Engineers Comments Regarding Surface Water Drainage

Application Reference:	AL/6/25/DOC	Reviewer Reference:	ADC/SB
Planning Officer:	Hannah Kersley	Date of Review:	21/02/2025
Site Name:	8 Autumn Gate Hook Lane Aldingbourne PO20 3TE		
Application Description:	Approval of details reserved by condition imposed under reference AL/75/24/HH relating to condition number 4 - surface water drainage scheme.		
Assessment Number:	1 of 2

Response	Condition 4: Objection
-----------------	-------------------------------

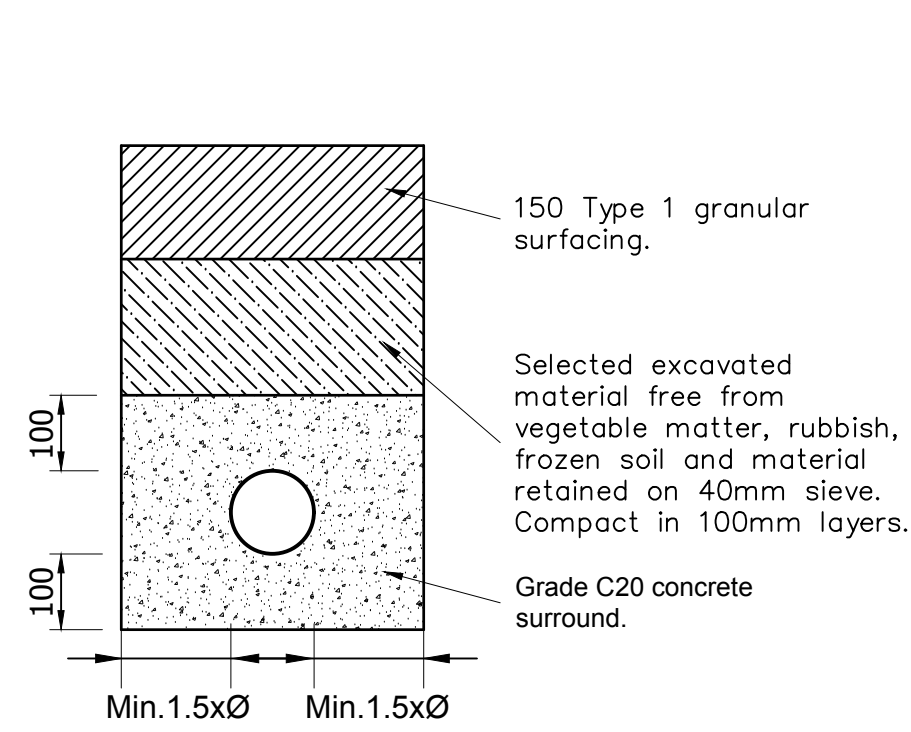
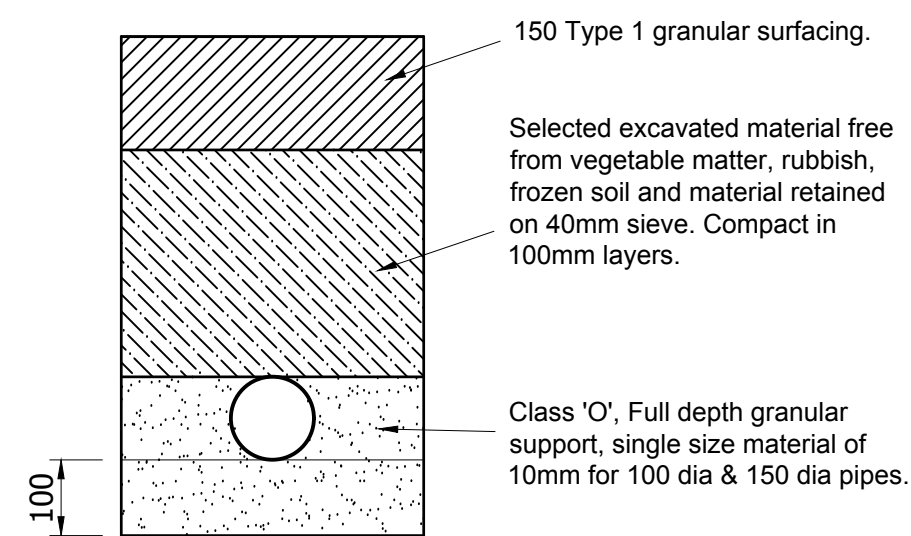
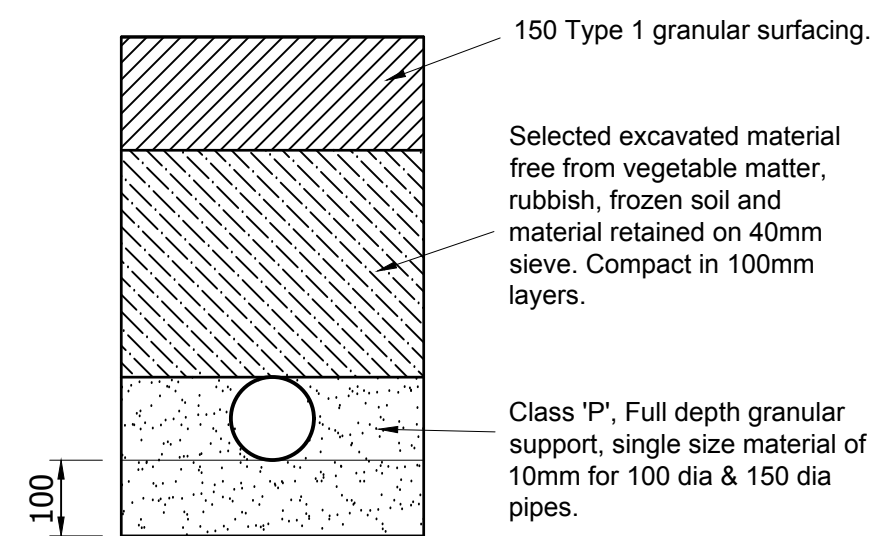
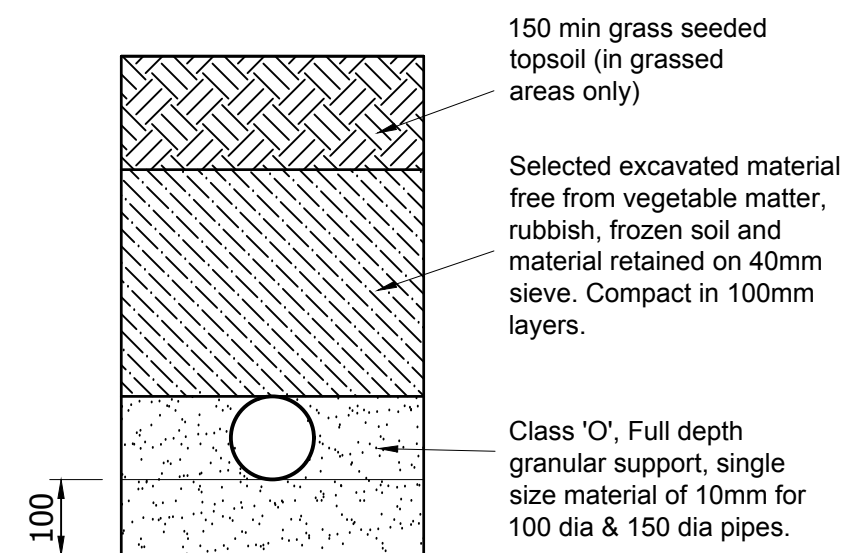
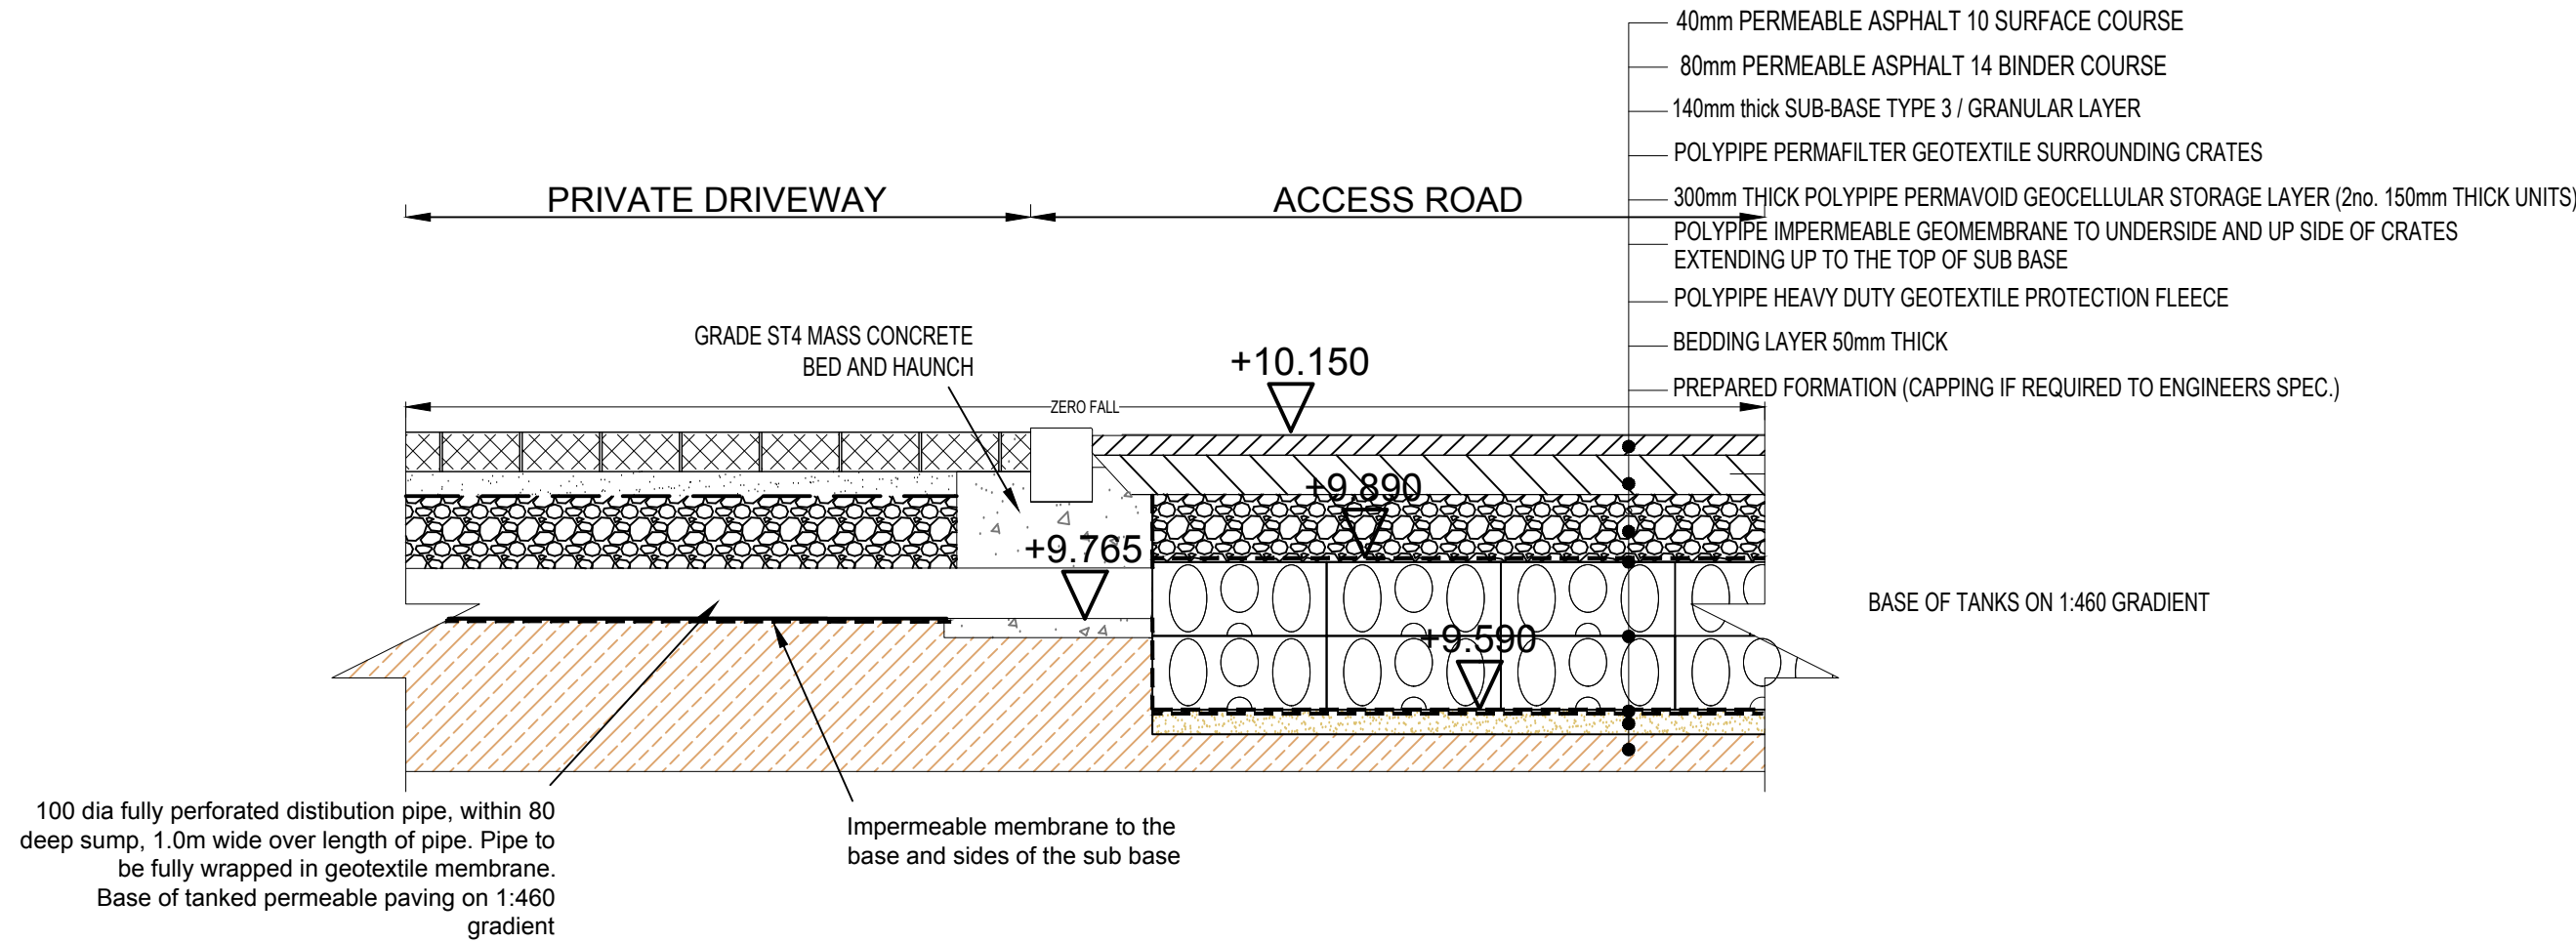
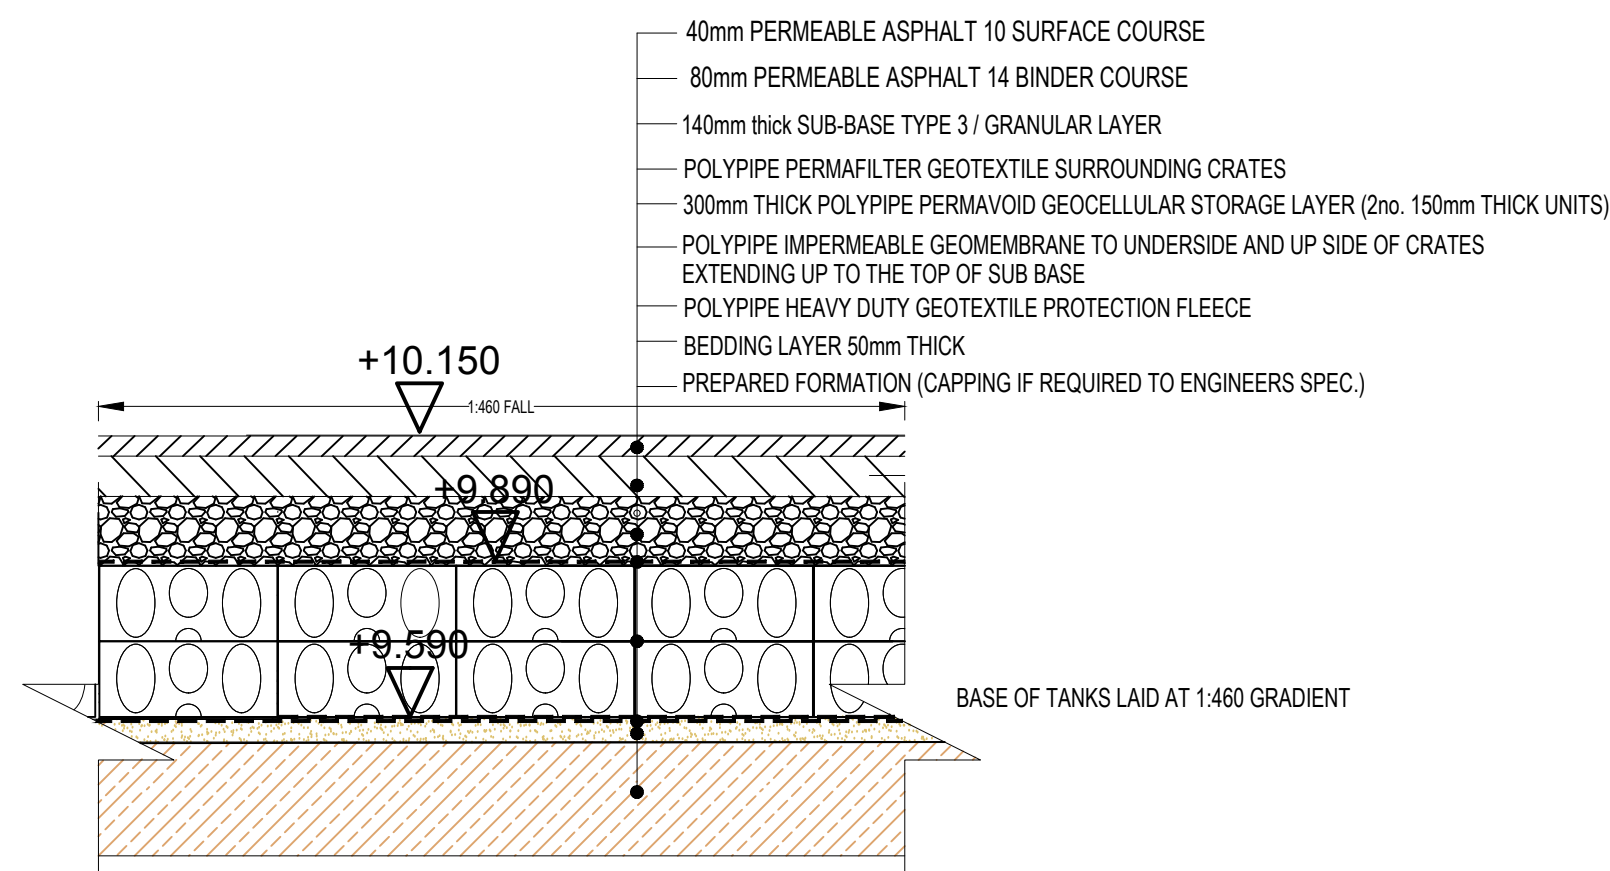
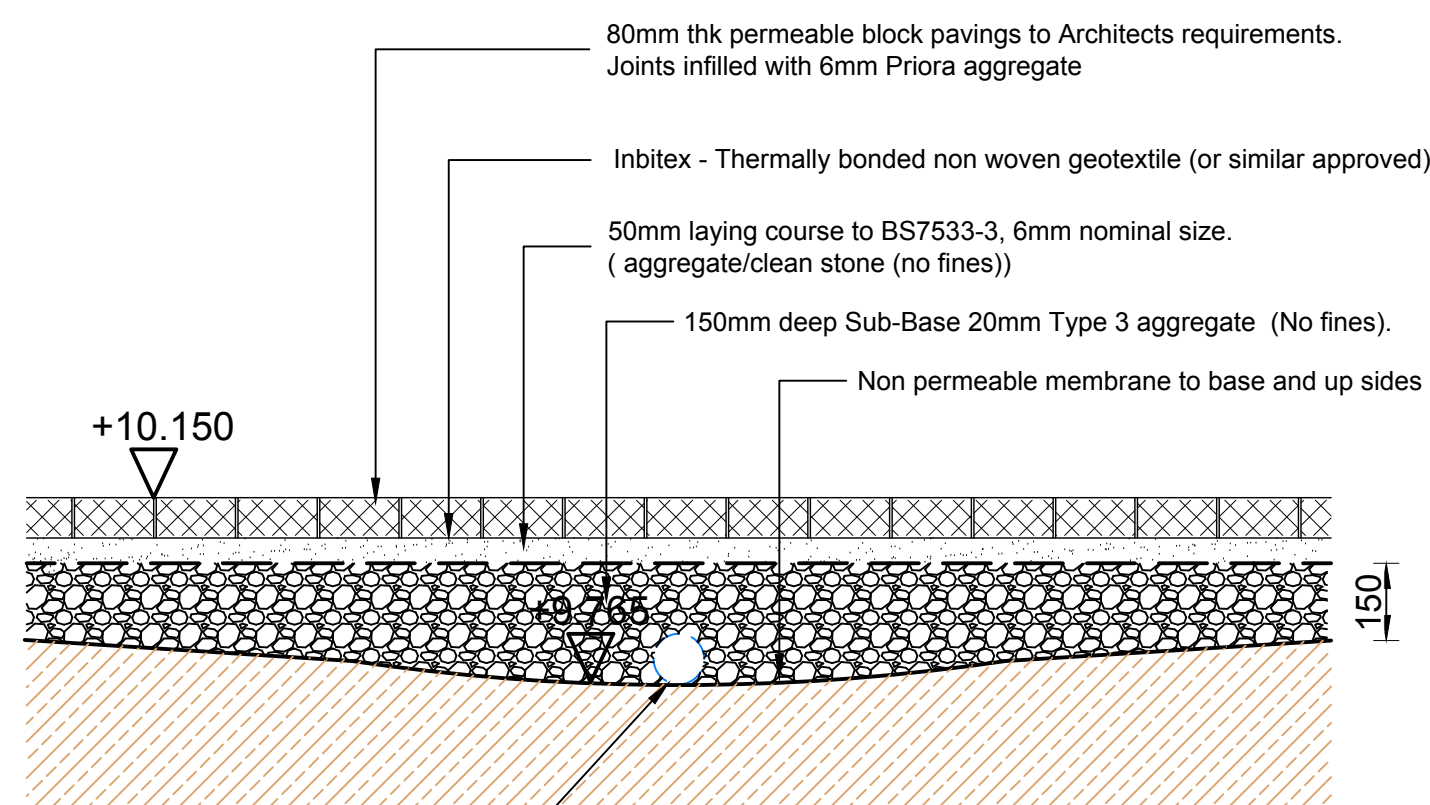
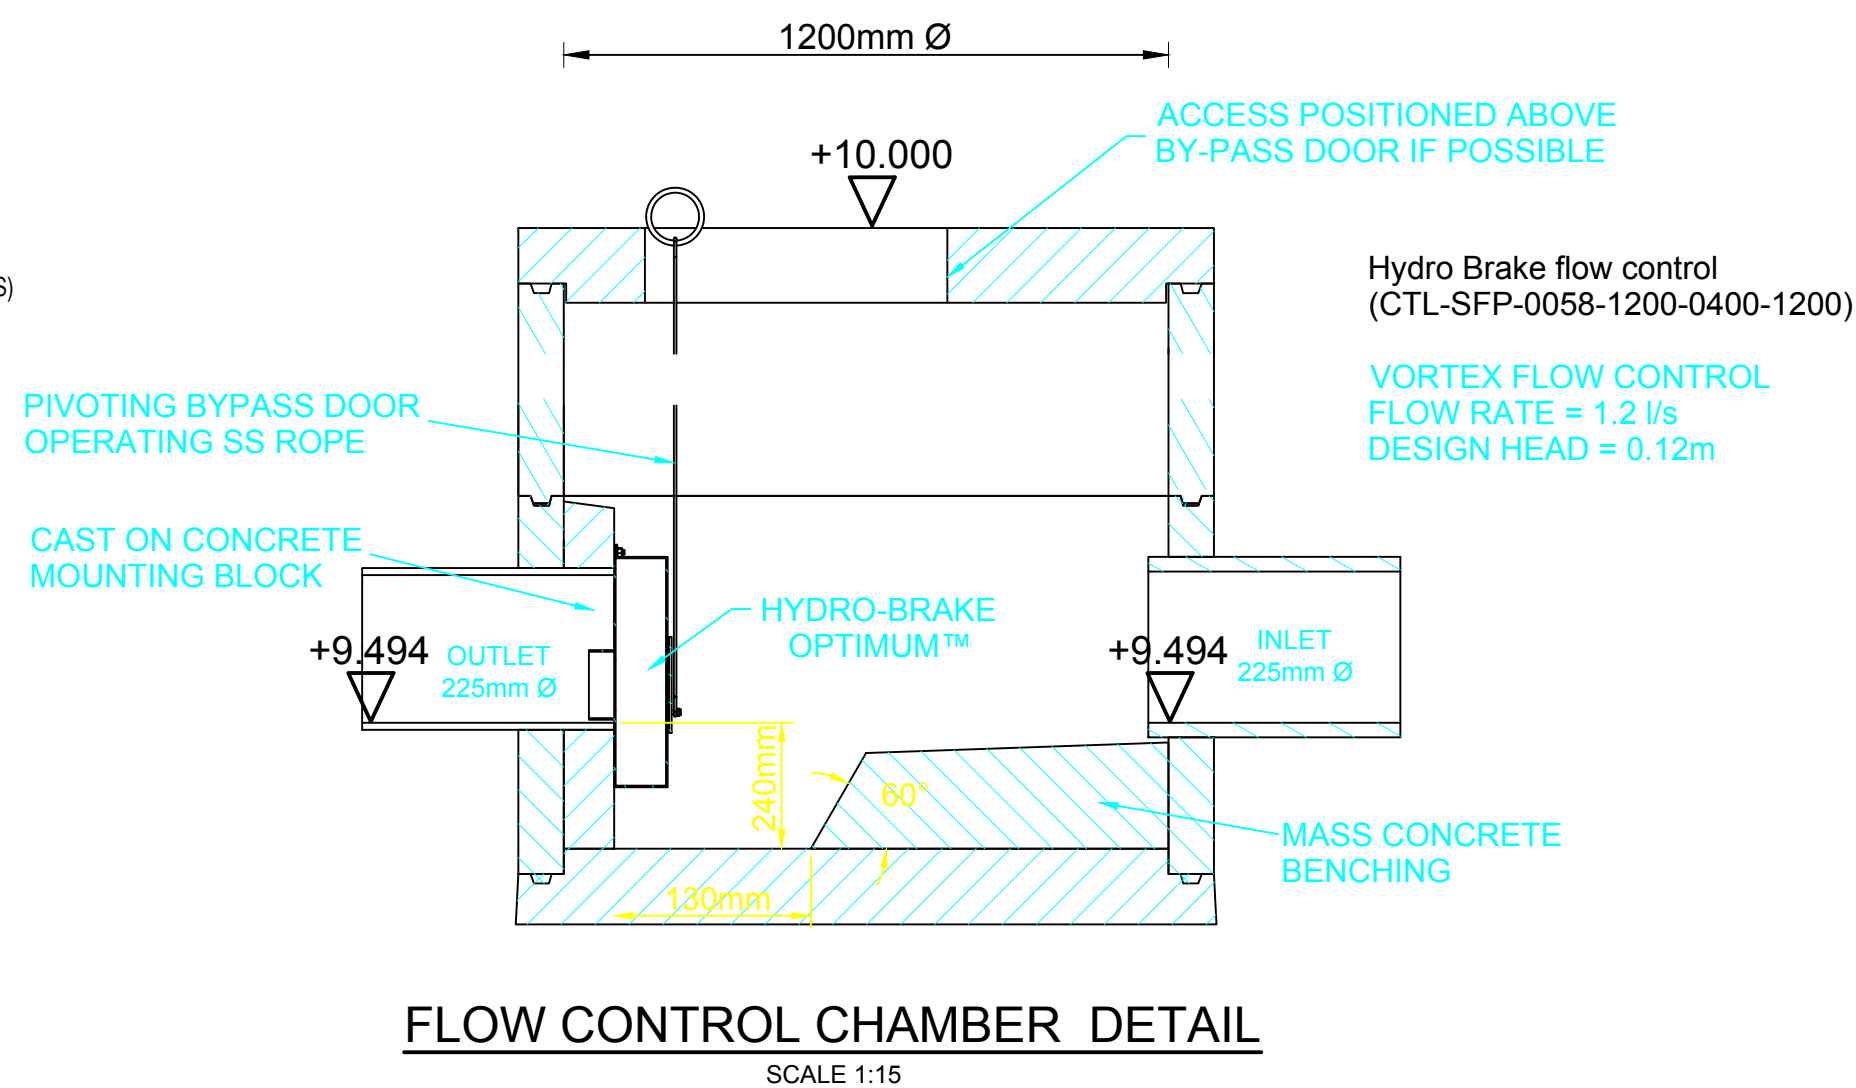
- ☒ Construction detail drawings are site specific. **May need additional – proposed extension specific**
- ☐ Construction detail drawings are provided for all components including but not limited to:
